Ferring Parish Council
Ms Nadine Phibbs
1 Elm Park
Ferring
Worthing, West Sussex
BN12 5RN

Application No: FG/47/22/HH
Site Address: 31 South Drive Ferring BN12 5QU
Description of works: Approval for replacement of roof void window to sliding doors.

PROP. SOUTH ELEVATION 1:100

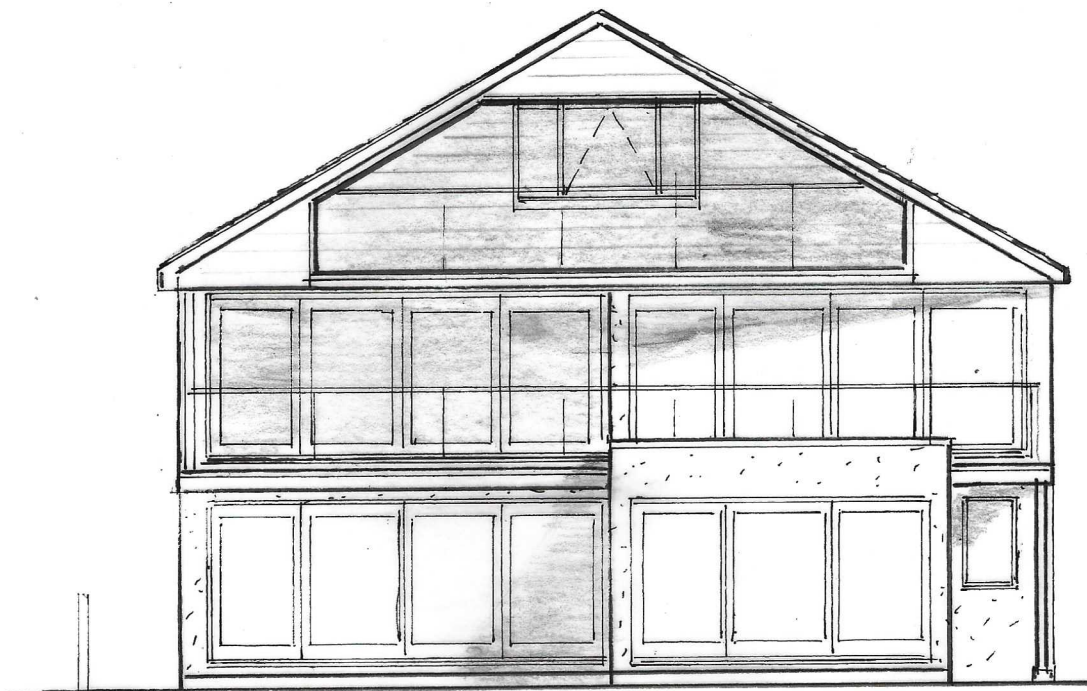
The built structure giving second floor access to a balcony directly overlooking the neighbouring private amenity space is an unacceptable loss of privacy for those neighbours which will negatively impact their enjoyment of their amenity space.

Replacement dwelling.
Roof void plan showing
sliding doors onto balcony.

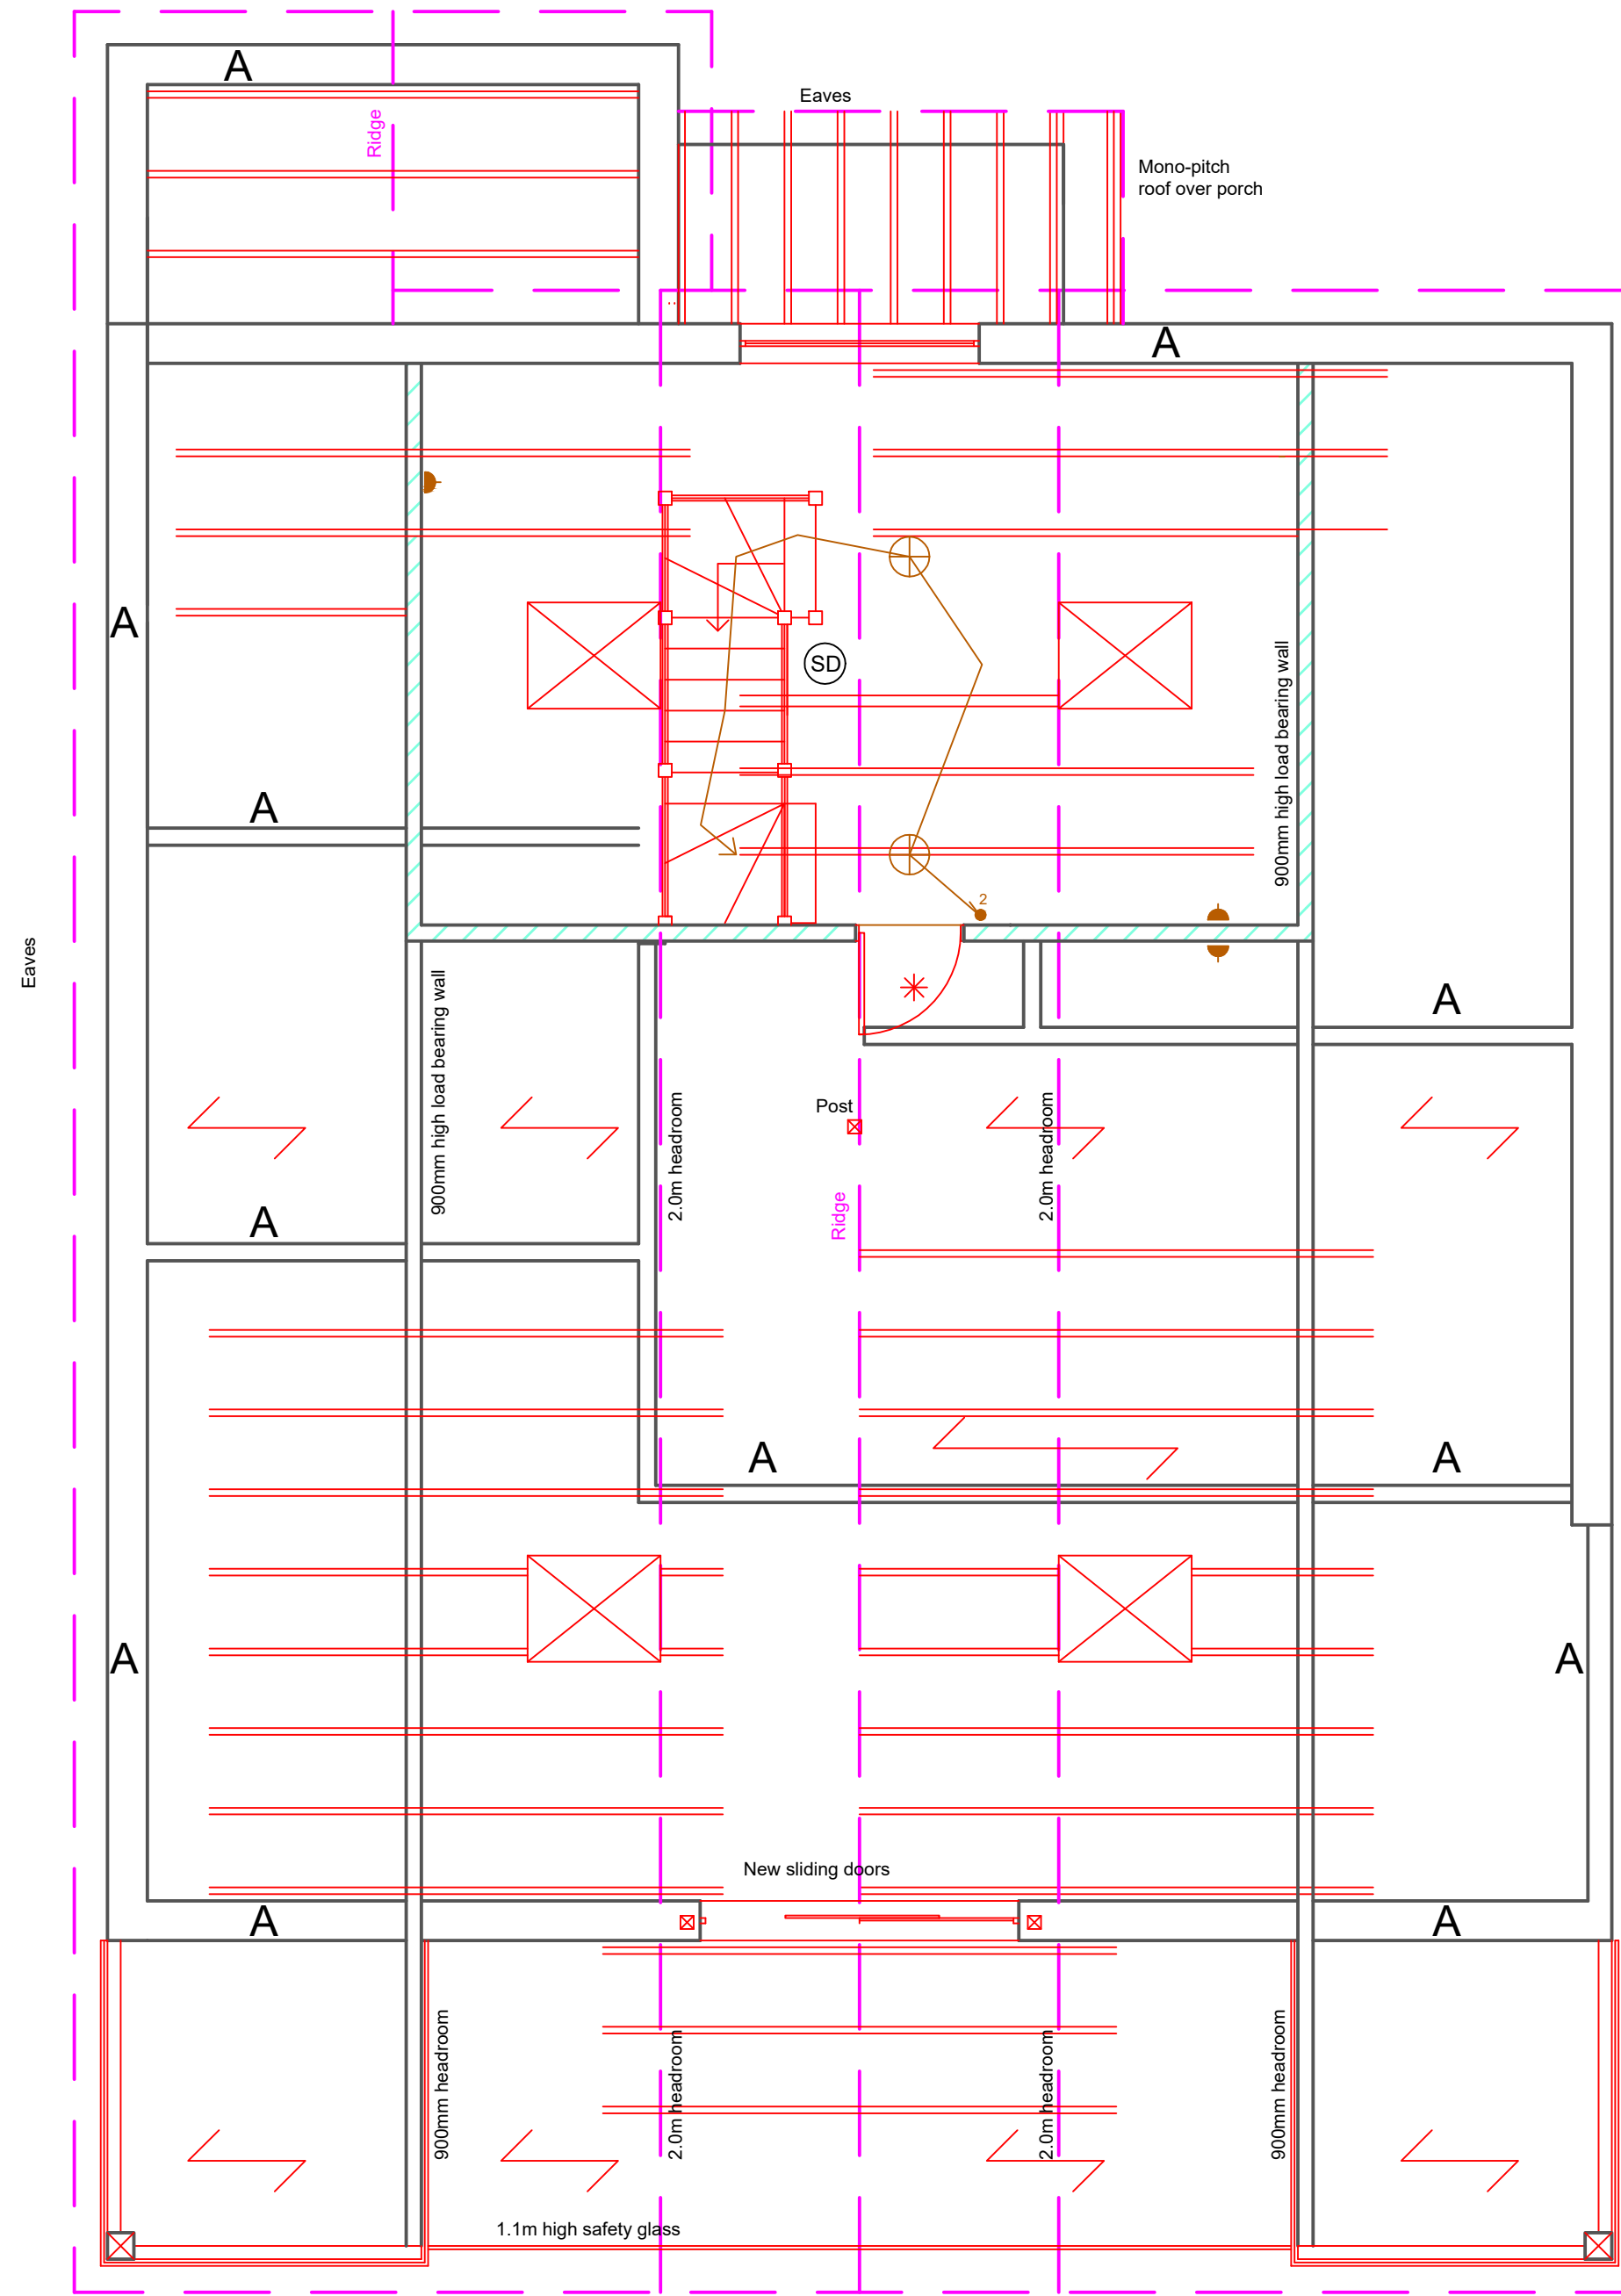
No consent was given for a second-floor balcony, which would not have had any means of access.

design, use of a balcony at 2nd floor level should be removed together with any opening doors or other access onto it.
